August 18, 2021

The purpose of this drainage letter is to satisfy requirements of the El Paso County Site Development Plan (SDP) submittal for the Colorado Centre Metropolitan District (CCMD) administrative building. In 2015, CCMD submitted a drainage report for the water treatment plant and future administrative building on the project site located at the northeast corner of the intersection of Flagstone Street and East Anvil Drive. At the time, the water treatment plant was planned for construction with the administration building to be constructed in the future.

Update to PCD File
No. PPR-21-051

**PROPOSED CONDITIONS**

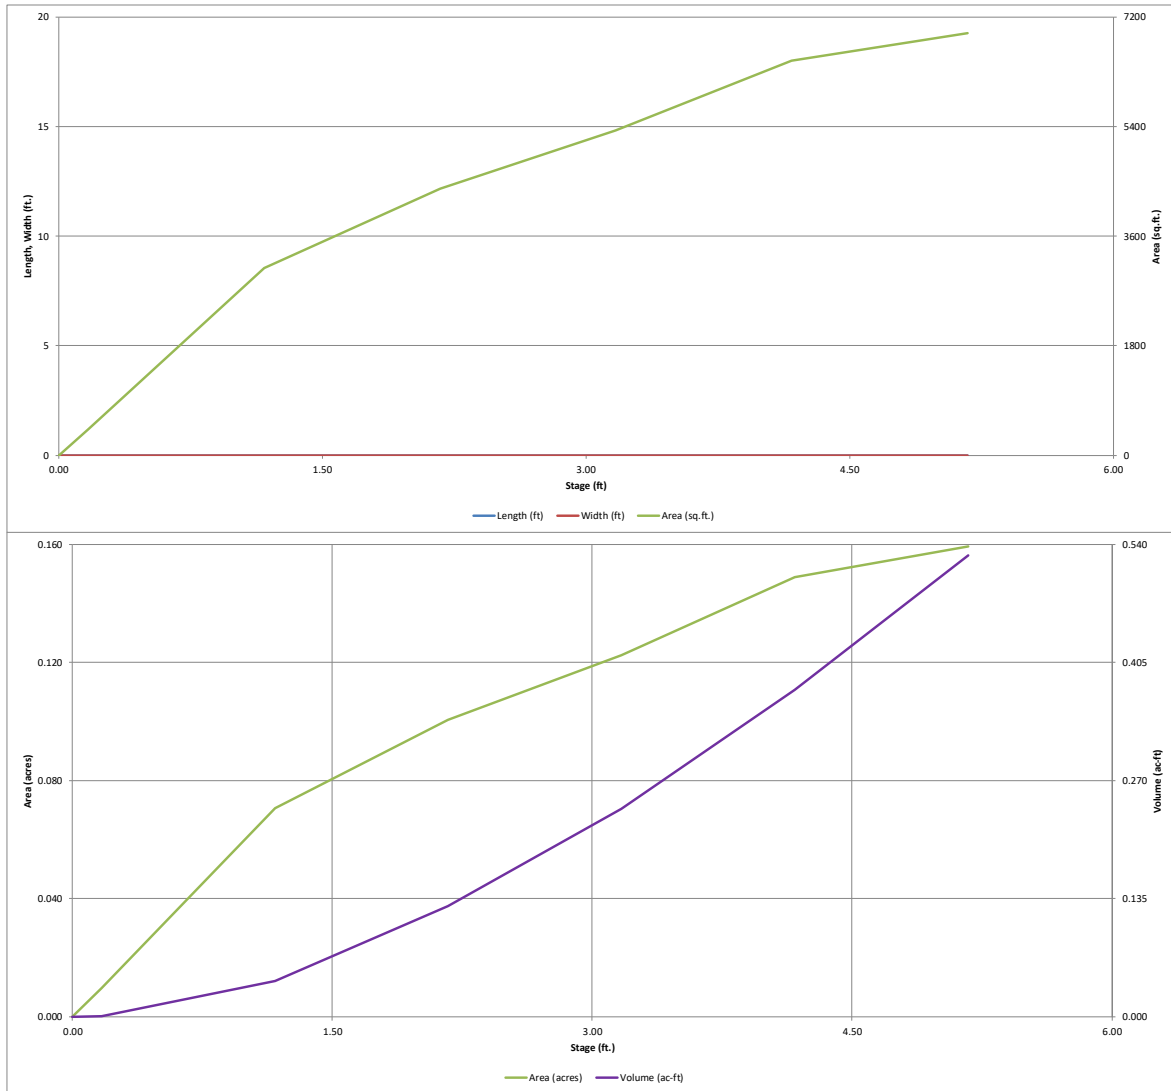
This values does not match Site Dev Plan
